Email: Graham.northern@northnorthants.gov.uk
Our Ref: NWP/21/00086/PREF
Date: 20.09.2021

Application No: NWP/21/00086/PREF

Proposal: Residential redevelopment comprising the erection of 3 detached dwellings

Location: Land At 57 Mears Ashby Road, Earls Barton, Northampton

TREE SURVEY AND CONSTRAINTS PLAN

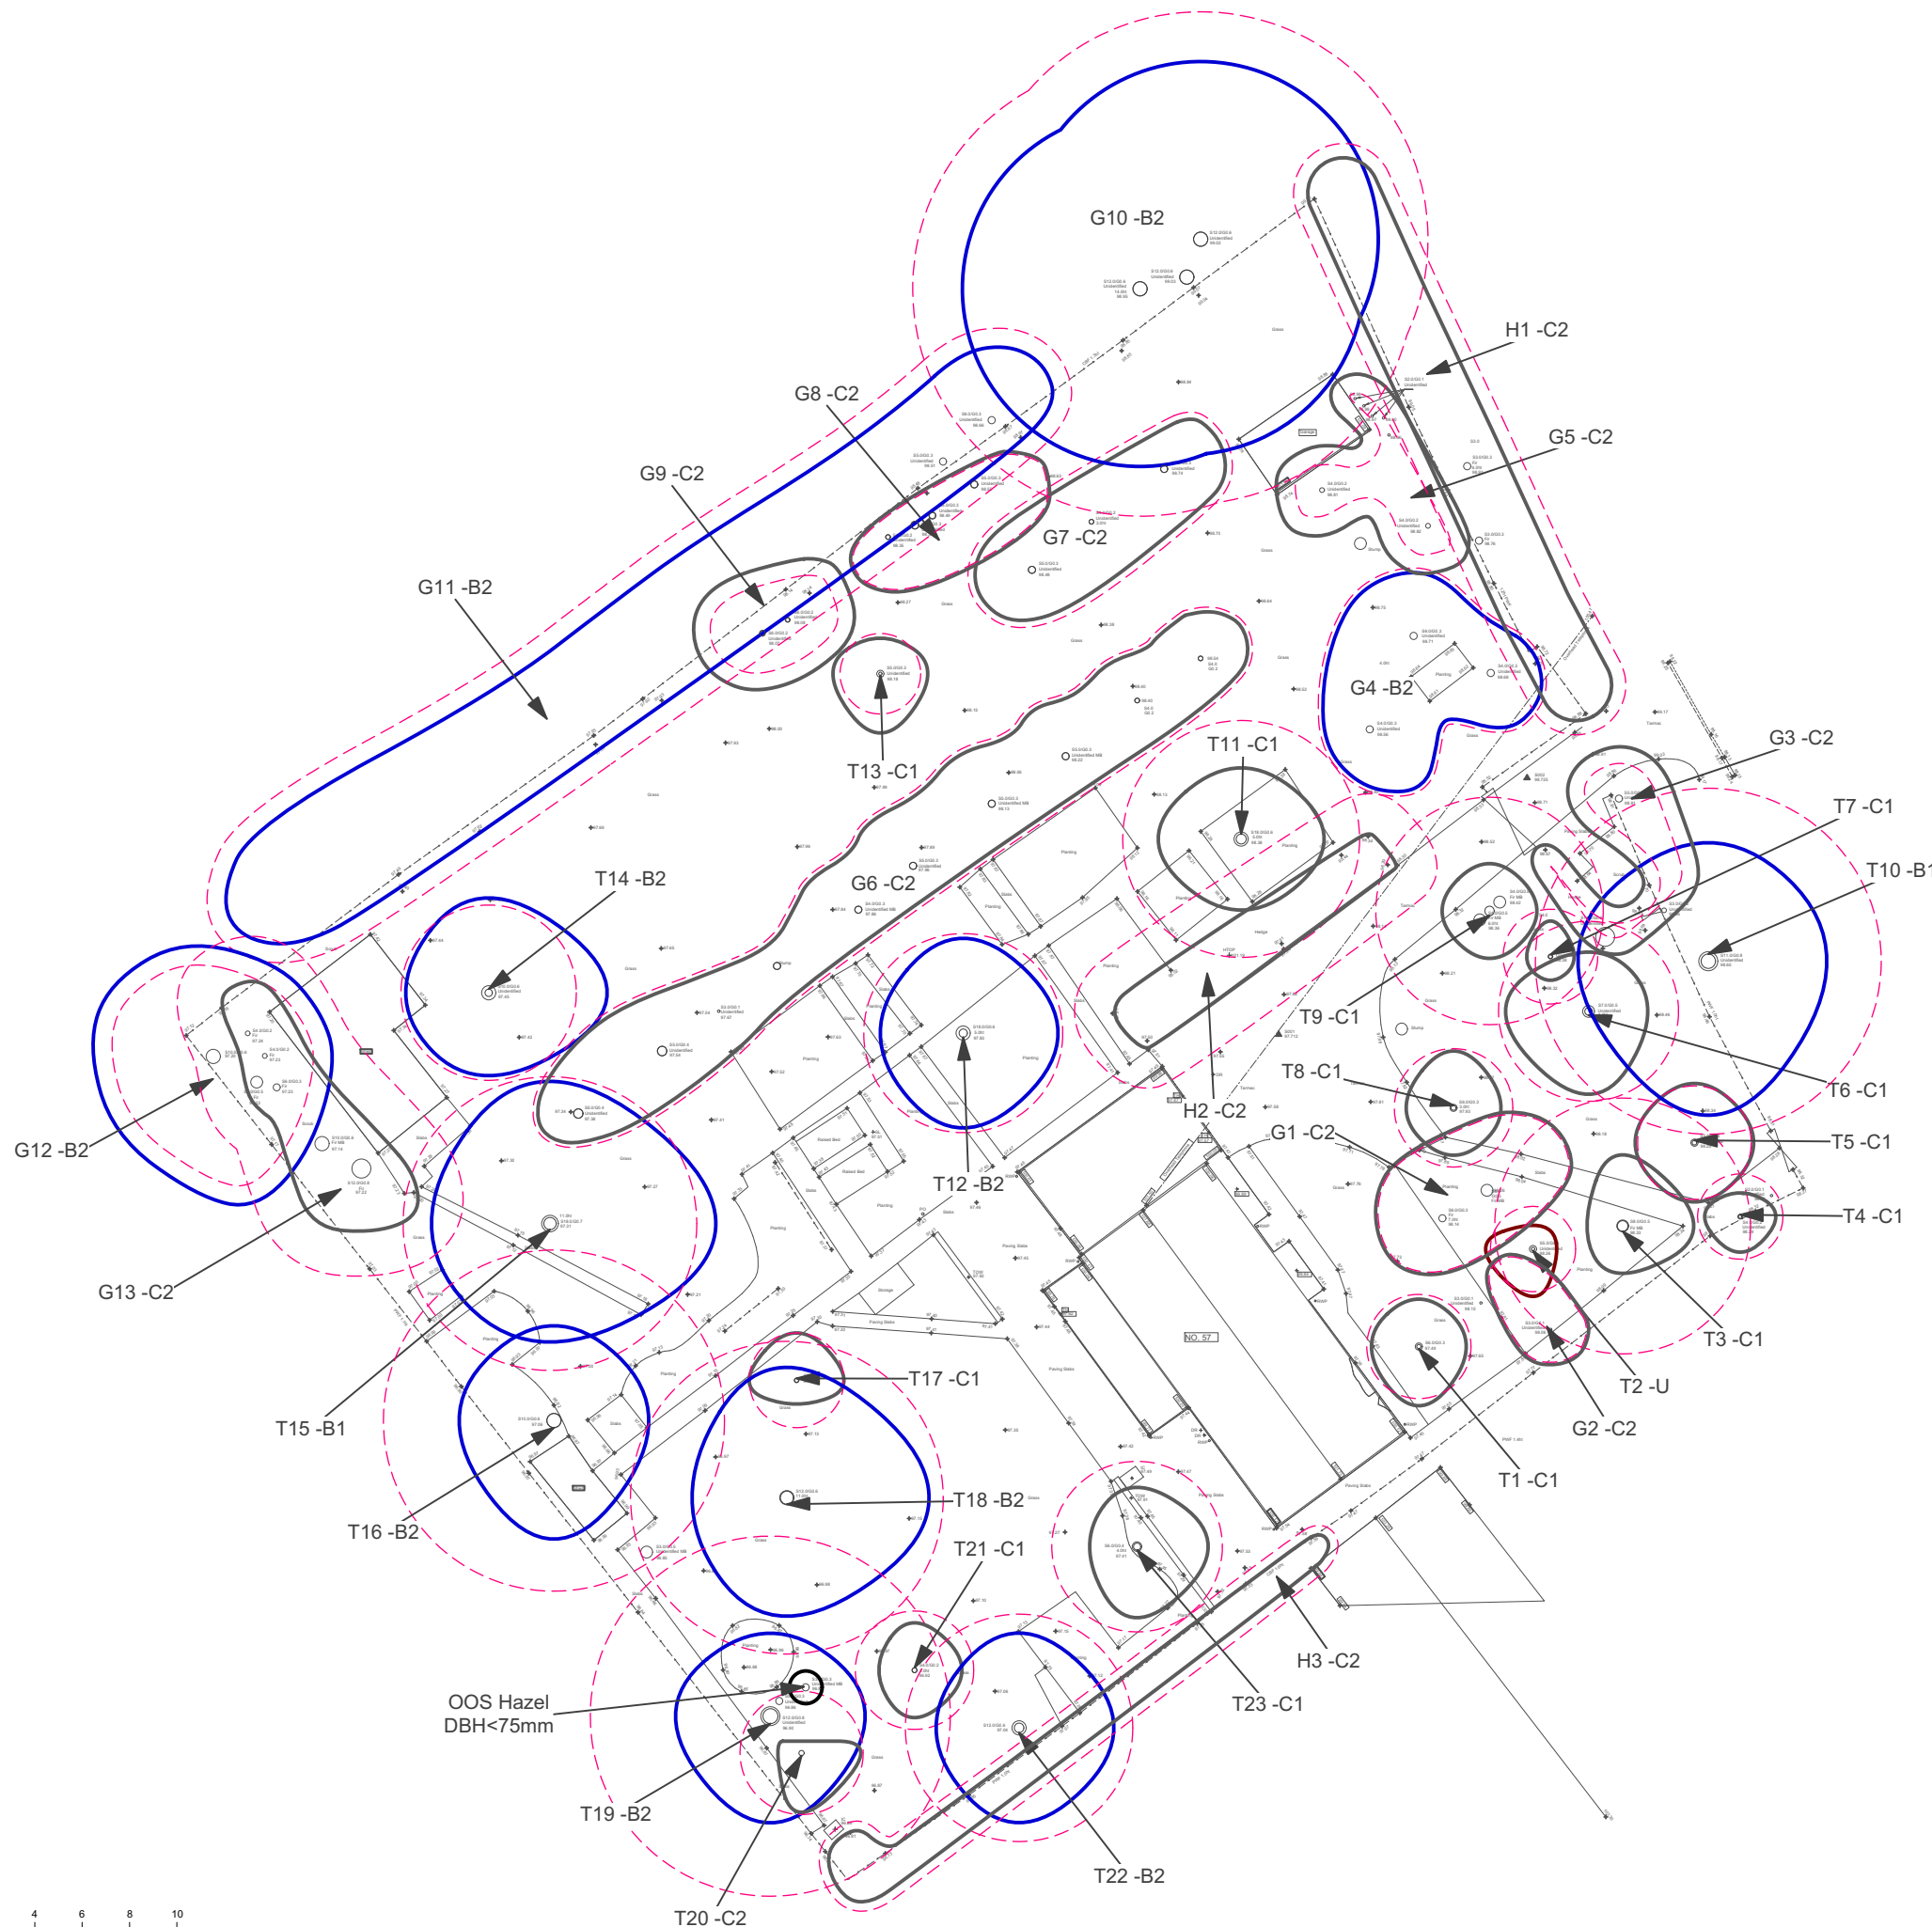
Landscape Officer - There is a significant oak tree just outside the front boundary hedge which appears to be in the way of the proposed access to plot 57 and it should be possible to rearrange the access points for 57 and 58 to accommodate the tree with the root protection area plotted and appropriate protection measures. The hedge is a mixture of conifer, dying elm, lilac (*Syringa*) field maple and beech.

The canopy of the broadleaved trees (beech and maple) which overhang the boundary from 63 by about seven metres would suggest that the parking area should be of no-dig construction. There are trees and cherry laurel all along this boundary.

Set in from the rear boundary there are three walnut trees and two oaks. The side garden of the property as it stands was for many years a productive vegetable garden and orchard. There are two rows of fruit trees, the first with nine to ten trees, the second of which supports a growth of mistletoe. The parallel row is of four trees with a few more near the boundary and there are other fruit trees and a few conifers scattered around the front garden.

A comprehensive tree survey should be provided, and consideration given to how it may be possible to achieve net biodiversity gain rather than loss.

A tree survey would also be required, and the proposals would need to demonstrate a net gain in biodiversity.

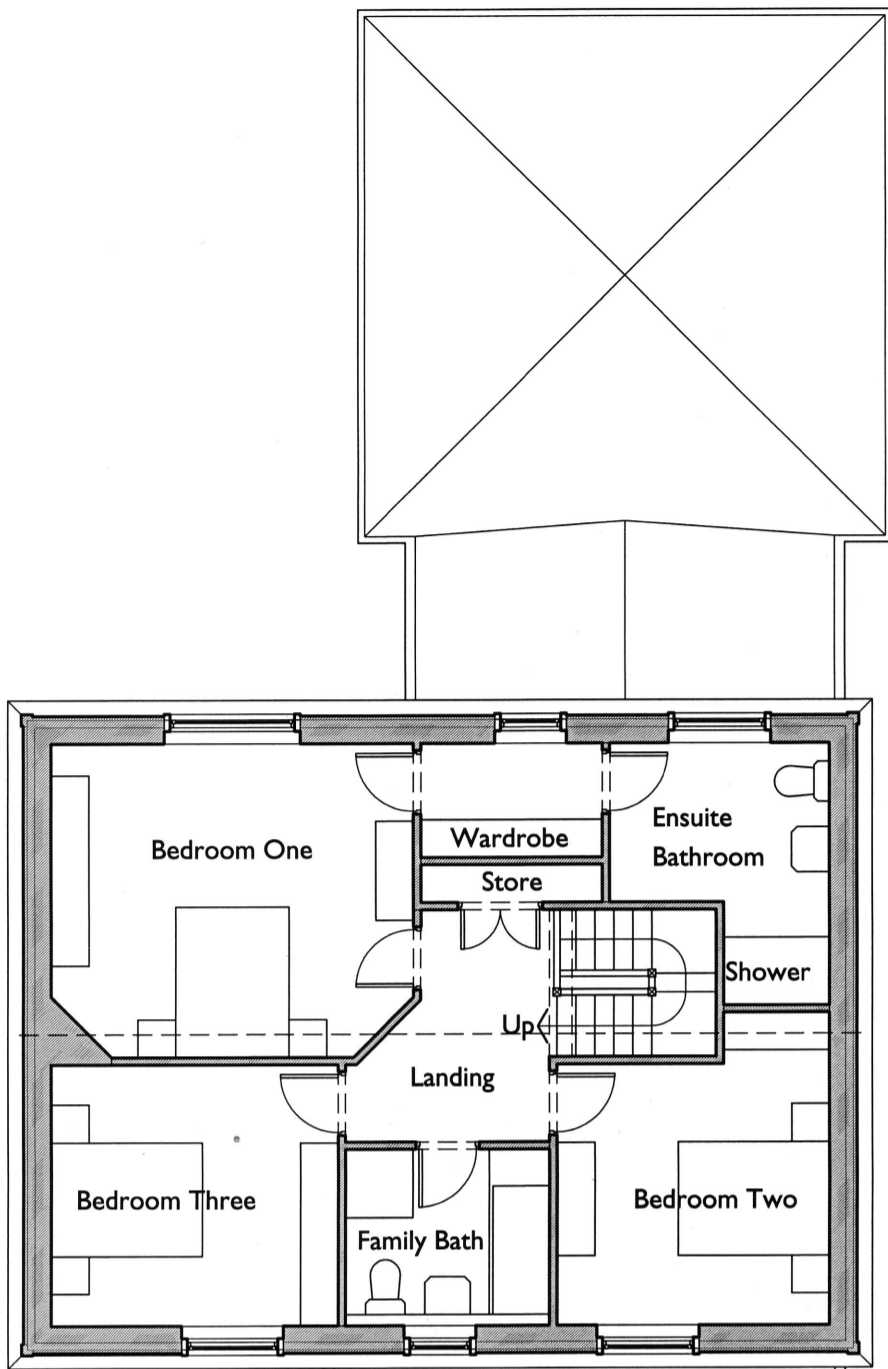
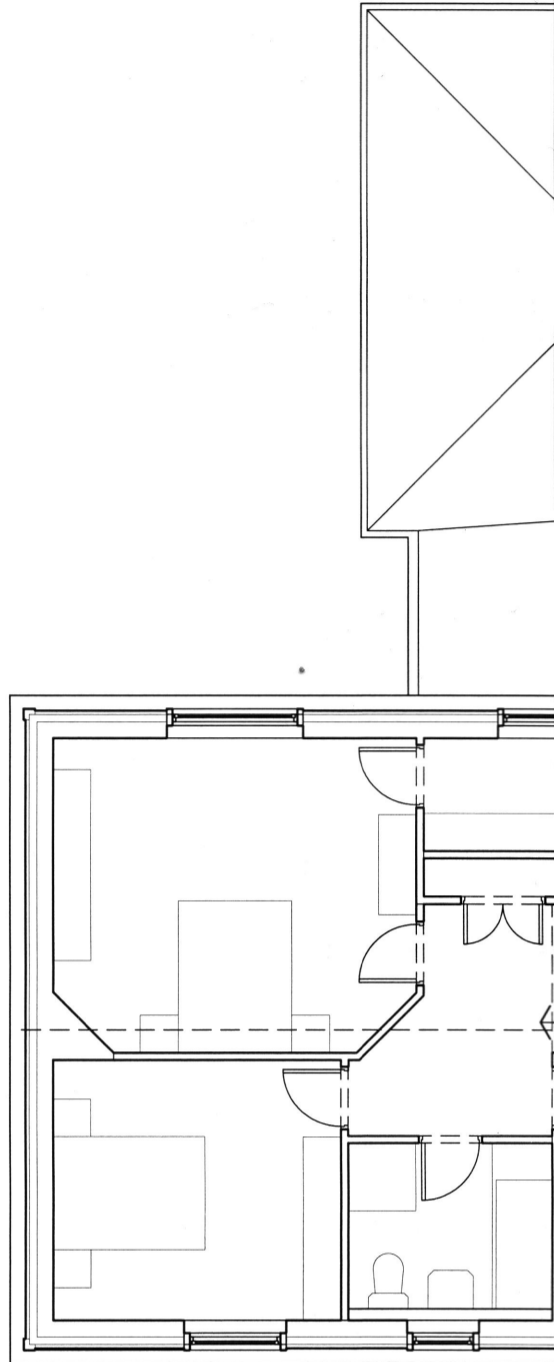
The site is constrained by trees/ hedgerows which present obstacles and the density is a significant increase whereby a proposal for two dwellings may enable greater tree retention and better suit the streets character.

The layout shows 3 properties of a uniform type, similar size and shape and all appear the same which is uncommon in the street scene and as such more variation would fit in more suitably with the street scene.
